From: Amanda Scholes on behalf of Planning.Responses
Sent: 06 February 2018 08:41
To: Planning Scanning
Subject: FW: Acknowledgement of new application M/116/17/CLP - Your ref: N/A

From: Ross Leal
Sent: 06 February 2018 08:29
To: 'Beverley Bennett'
Subject: RE: Acknowledgement of new application M/116/17/CLP - Your ref: N/A

Proposed Elevations

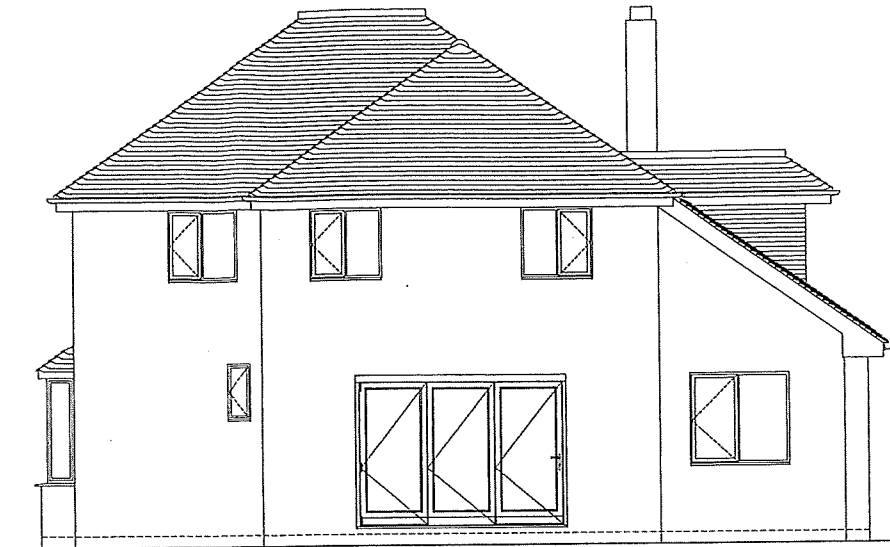
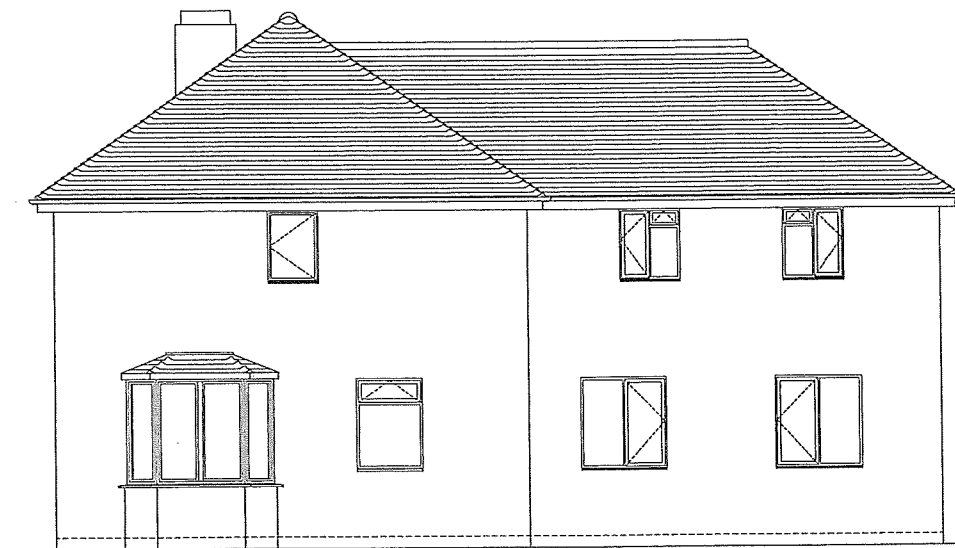
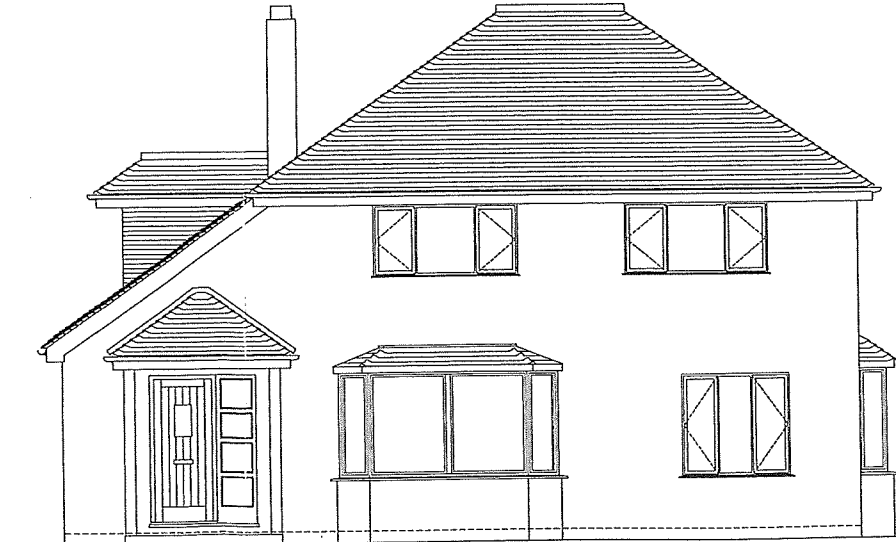
The windows also need to be non-opening unless the parts of the window which can be opened are more than 1.7 metres above the floor of the room in which the window is installed. Can you also confirm that this will be the 3 case please?

All materials will be matching existing build and the windows will both remain the same size and obscured.
